From: Sarah Burrow <Sarah.Burrow@arun.gov.uk>
Sent: 03 November 2020 16:18
To: Planning.Responses <Planning.Responses@arun.gov.uk>
Cc: Maria Tomalova <Maria.Tomalova@arun.gov.uk>
Subject: RE: Planning Consultation on: FP/201/20/DOC

Engineers Comments Regarding Surface Water Drainage

Application No: FP/201/20/DOC
Registered: 20th October 2020
Site Address: 7 Middleton Road Felpham PO22 6BL
Description of Works: Approval of details reserved by condition imposed under ref FP/203/17/PL relating to Condition No 4 - surface water drainage.

TYPICAL AQUACELL SOAKAWAY
(pedestrian and car/light van loading only).
(Scale 1:20)

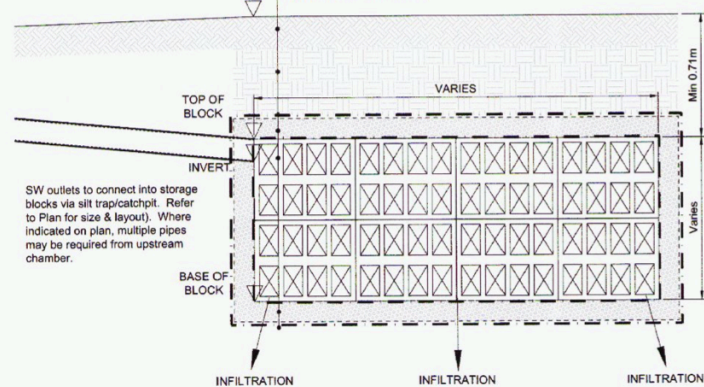
6. Linked to point 5; the soakaway construction details show a minimum cover depth of 0.7m, and the crates are 0.4m depth, yet depth of crates is stated on the drainage checklist as 0.9mbgl. With groundwater evidenced at 1m below ground level the crates must be kept at 0.9mbgl as a minimum. The construction detail will need to be amended to reflect this. If necessary the specified crates will need to be changed to ones that are suitable at shallower depths in vehicular areas.

TYPICAL SECTION THROUGH FORMPAVE AQUAFLOW INFILTRATION SYSTEM

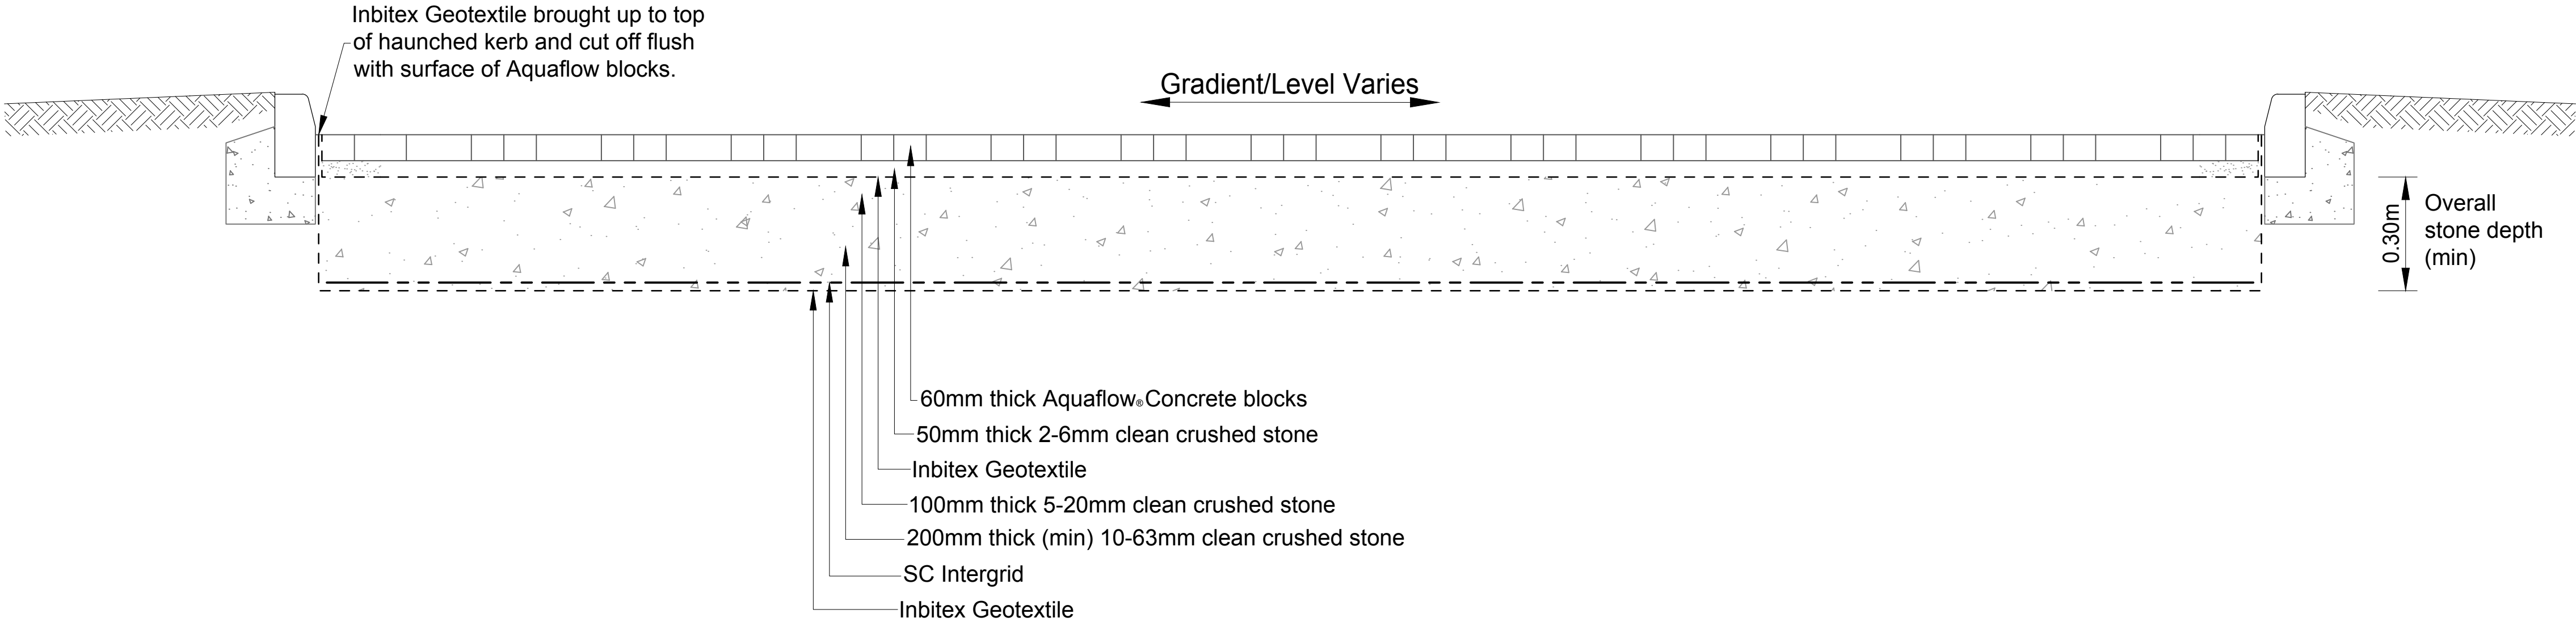
5. Permeable paving is shown on a separate drawing to the drainage layout without consideration of how it will interact with the soakaway below. It may be worth considering a permeable paving solution which half the property and the garage can drain into via diffuser units. As a minimum the permeable paving should be detailed on the Drainage Plan and 'Clean Crushed Stone' will need to be specified as Type 3 reduced fines or 4/20 or similar to be suitable for the engineered fill. A construction detail will also need to be supplied to show the layers from the block pavers to the bedding layer of the soakaway crates.
